SUBMISSION FOR APPLICATION No. SSD5752

Please find the submission below that strongly OBJECTS to the current Development Application SSD5752.

ICC CONVENTION

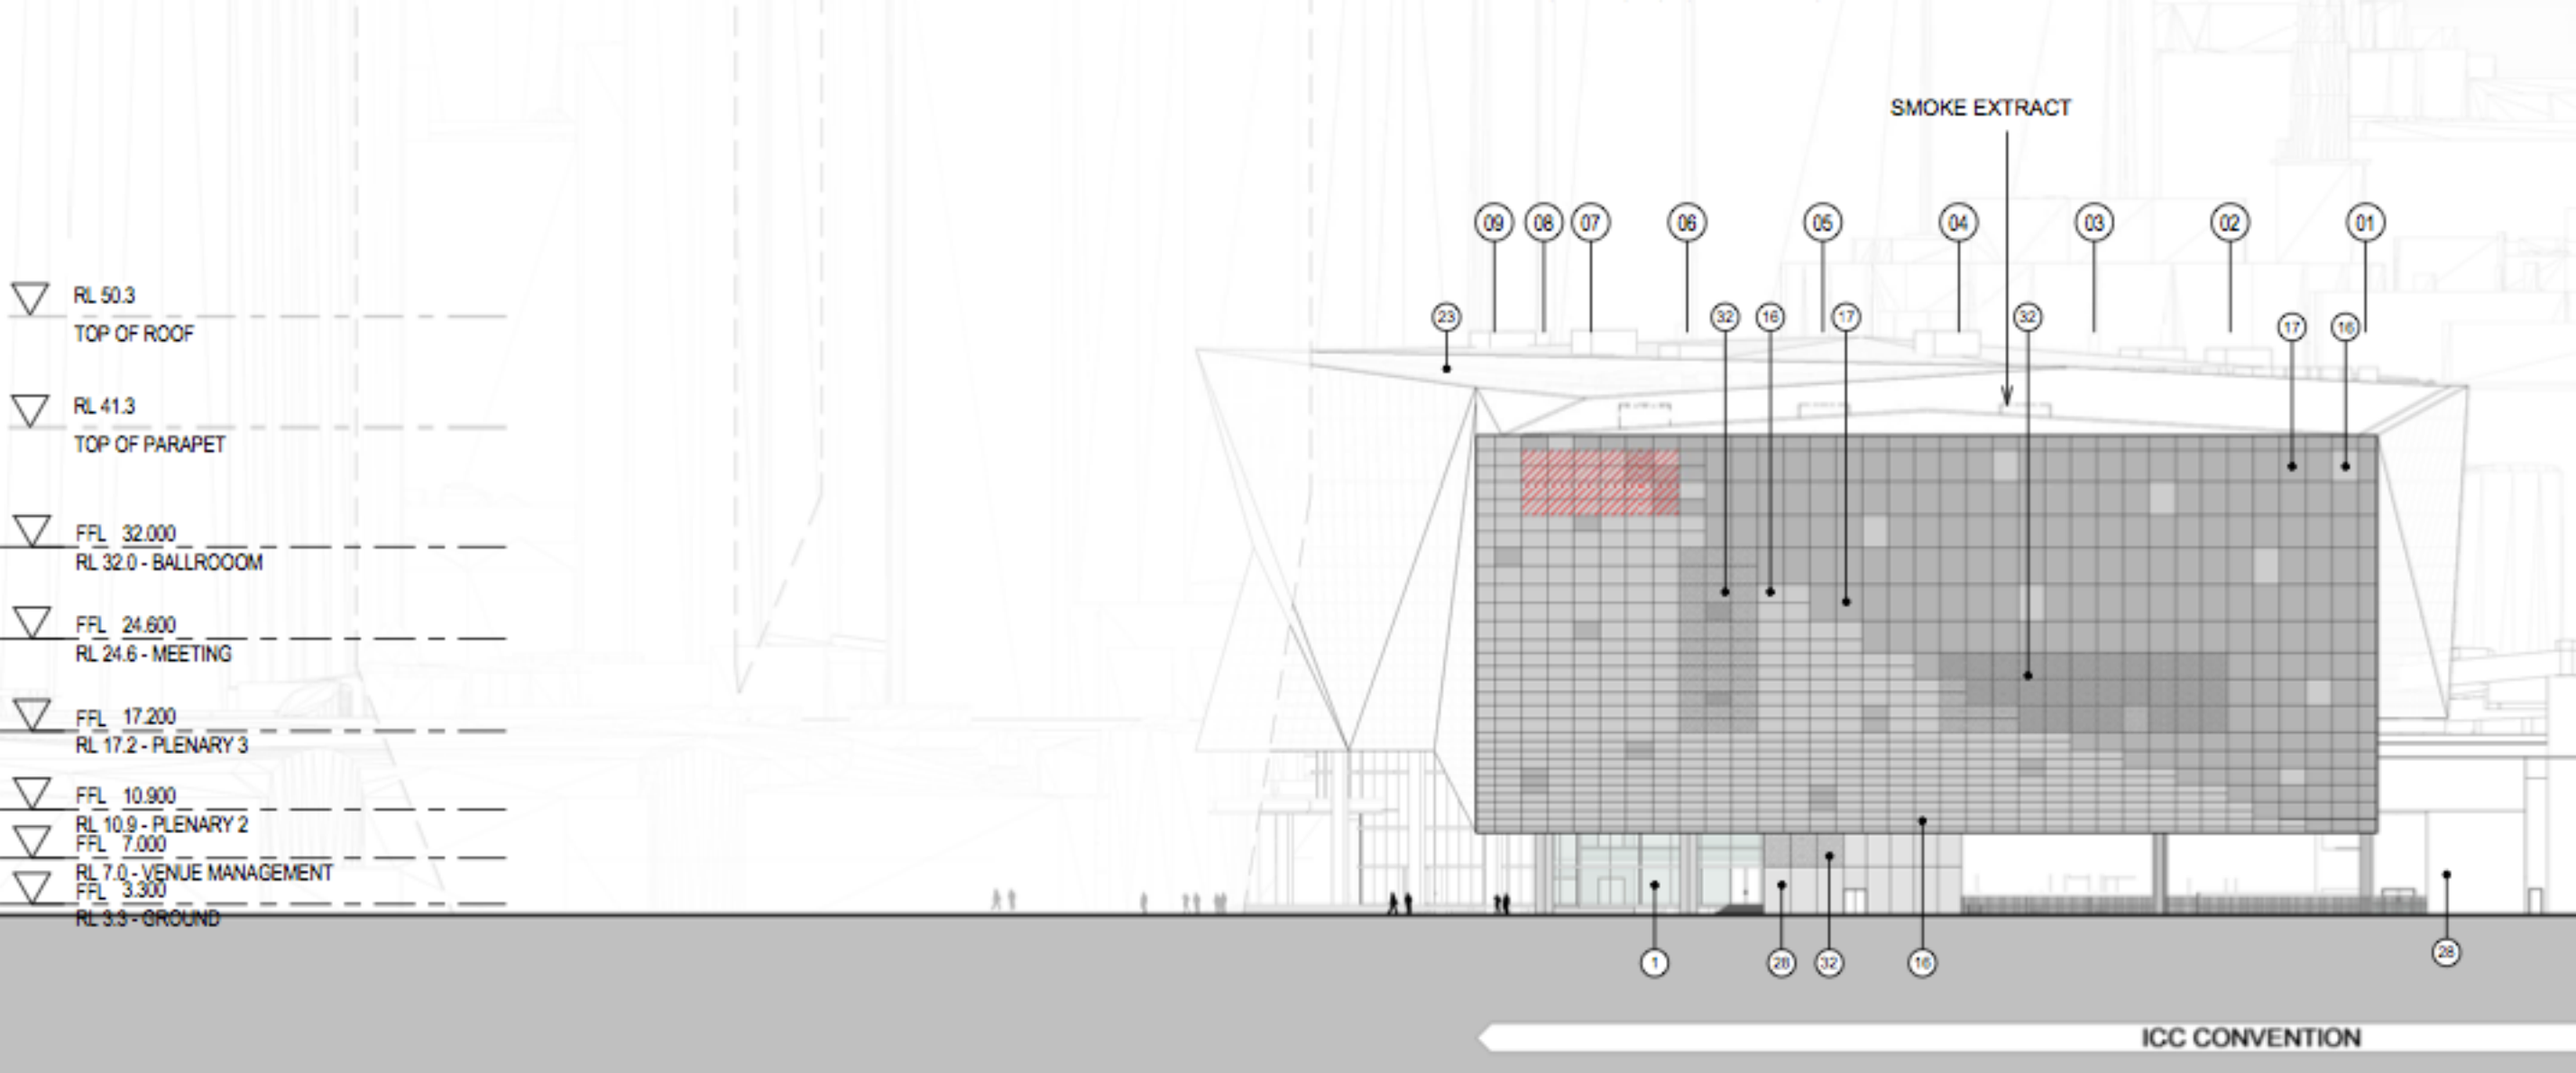
We object to the height of the proposed new ICC convention centre which is nearly to the top of the Goldsbrough's current height.

In the DA plans the proposed height is RL 50.3 which will block the entire view to Darling Harbour and the city from the Goldsbrough's eastern facing apartments.

In place of the current city skyline and Darling Harbour view there will be a flat blank metallic wall in its place, which is the rear of the proposed ICC convention building.

The Goldsbrough residents on the eastern side will be facing an ugly flat back wall made of aluminum.

DRAWING TITLE
 GA PLANS - LOBBY - LEVEL 0 (RL 3.3)

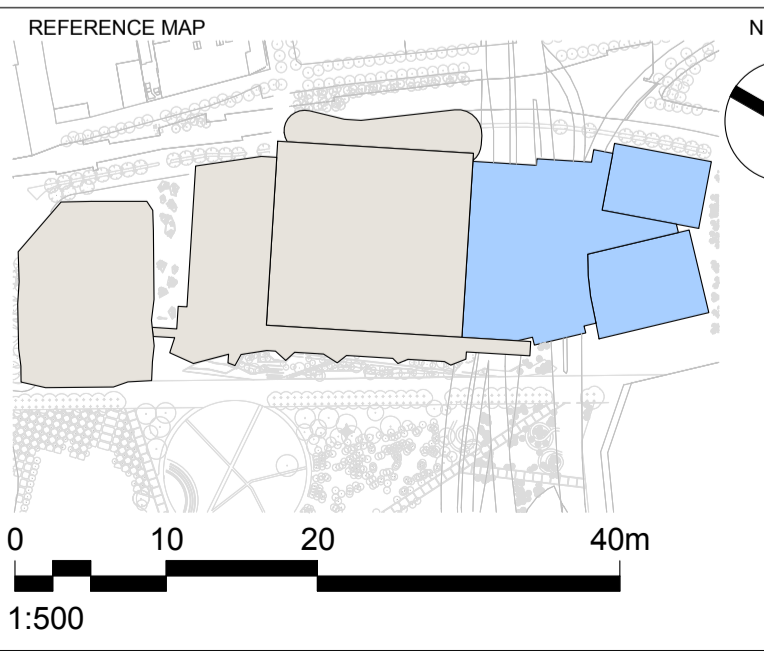
From the plans it looks like the current overhead pedestrian walkway next to the Convention monorail station is being removed. Currently it is the easiest and safest walkway to enter the Darling Harbour precinct from the Western side.

If this entry to Darling Harbour is removed it will be a total disaster for many of the pedestrians who regularly use it as well as visitors to the area. Currently it is estimated that there are around 7000 pedestrian traffic movements across this walkway on a regular day and many more on busy event days. It is the only safe way to cross the light rail tracks and Darling Drive and is the direct access for 2 major carparks servicing Darling Harbour. This walkway is open 24 hours a day, 7 days a week with continuous public access.

The alternative link from the Western Distributor is not a convenient alternative to what is currently there. How are pedestrians especially with children meant to cross to and from Darling Harbour in a safe way at all hours?
